HTE# 15-5-36769RR

EXISTING SEPTIC SYSTEM INSPECTION

NAME OF MOBILE HOME PARK OR S/D KINNIS CREEK lot 36

PURPOSE OF INSPECTION: 24x28 Detached Garage

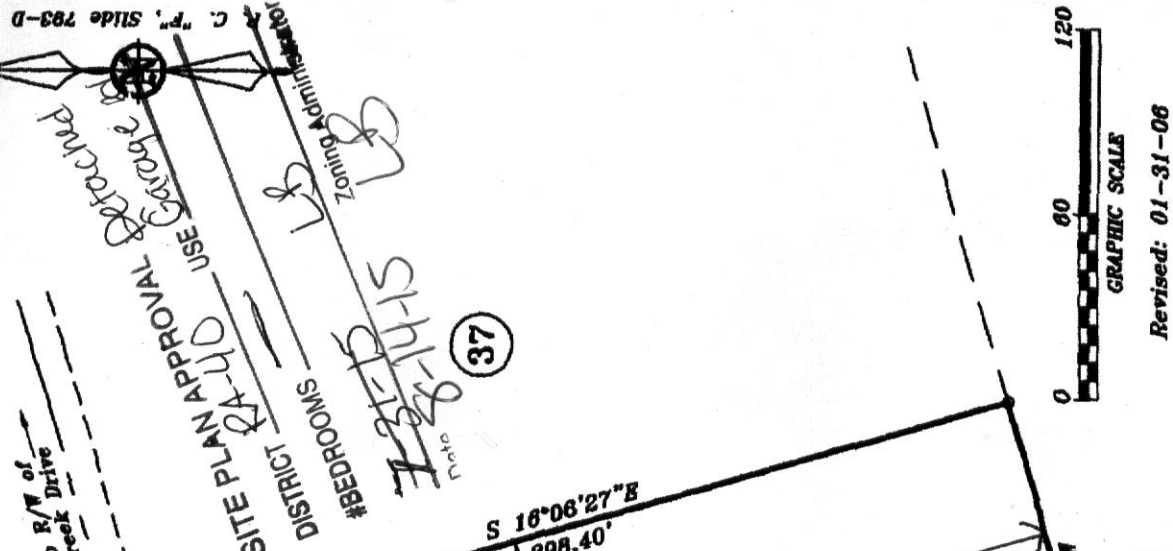
**BUILDING MUST BE 5' FROM ANY PART OF SEPTIC SYSTEM
DO NOT DRIVE OR PARK ON SEPTIC SYSTEM**
